KIRKLEES METROPOLITAN COUNCIL STATEMENT OF CASE
TOWN AND COUNTRY PLANNING ACT 1990

Appeal by Mr S Murphy against the refusal of Kirklees Metropolitan Council to grant planning permission for the siting of a mobile home as holiday accommodation, construction of raised platforms, erection of 'tiki bar' and pergola and formation of vehicular access from Manchester Road with electronic gates and associated hard surfacing at Mulberry Brook, Manchester Road, Slaithwaite, Huddersfield, HD7 6LP

Appellant:	Mr S Murphy
Appeal Site:	Mulberry Brook, Manchester Road, Slaithwaite, Huddersfield, HD7 6LP
Appellant's Agent:	Mr Andy Rushby, Assent Planning Consultancy Ltd
LPA Reference:	2021/91136
Planning Inspector Reference:	APP/Z4718/W/22/3290235

KABIN & DECKING PLAN ~ 1:100

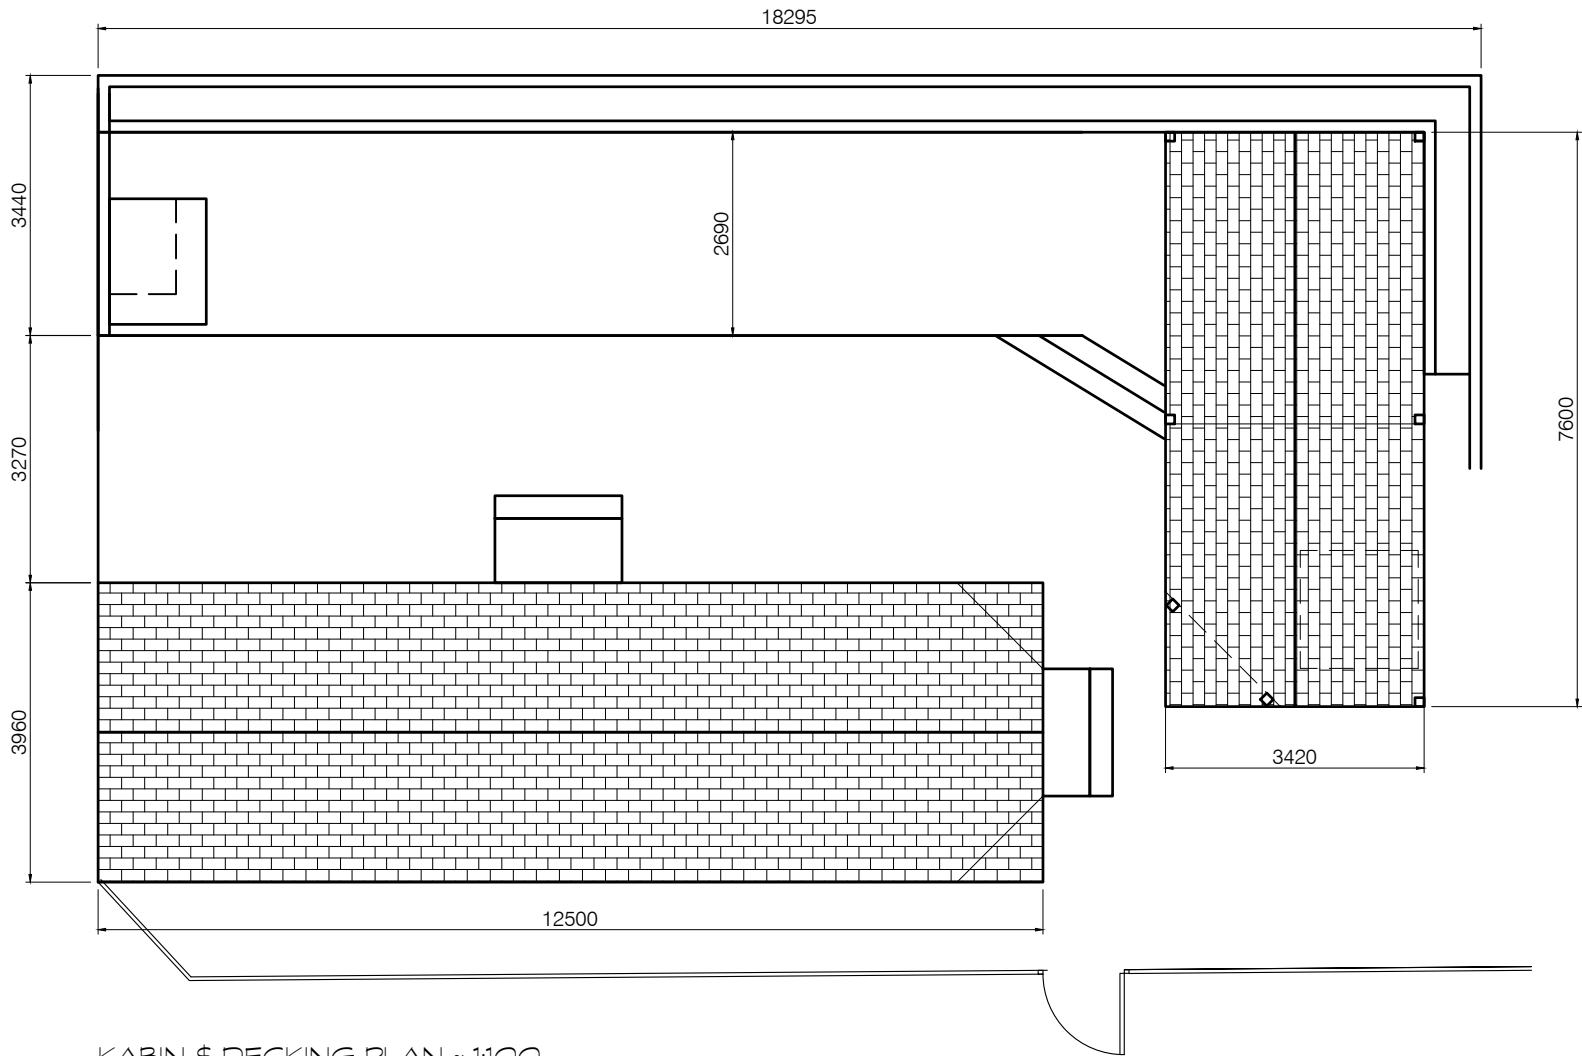
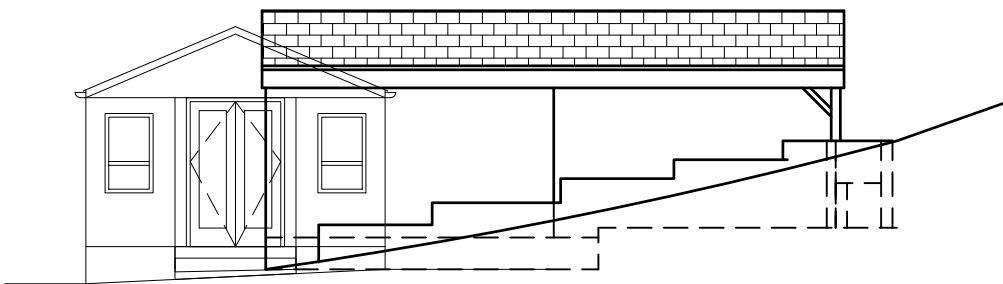
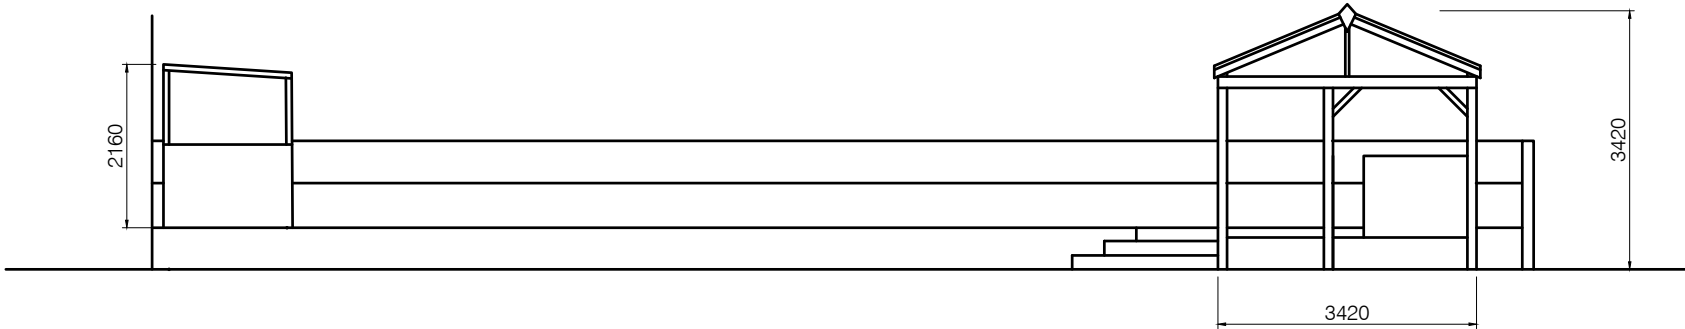
urbanising driveway, and the addition of domestic features such as decking, excavations works, a pergola and bar, which add to the harm to the openness of the Green Belt. In addition, the LPA consider that it unclear why the holiday home has to be so disconnected and isolated from the existing dwelling, rather than connected with it which would help reduce the harm to the openness (although the LPA are of the view that it would unlikely eliminate such harm). The LPA have recorded evidence of tourism self-catered accommodation once being provided within part of the existing dwelling at Mulberry Brook (called 'Jasmine Lodge') (see Appendix 3), but this now appears to have been taken down from a number of websites. The LPA hold the view that such accommodation within the dwelling would have less of an impact upon the openness of the Green Belt. The LPA therefore hold the view that 'Jasmine Lodge' (which is noted to be able to accommodate 6 guests on Air BnB, and pictures on the AirBnB and Facebook websites for Jasmine Lodge seem to confirm this), appears to be a more suitable option to provide tourism development in the locality than the cabin development.
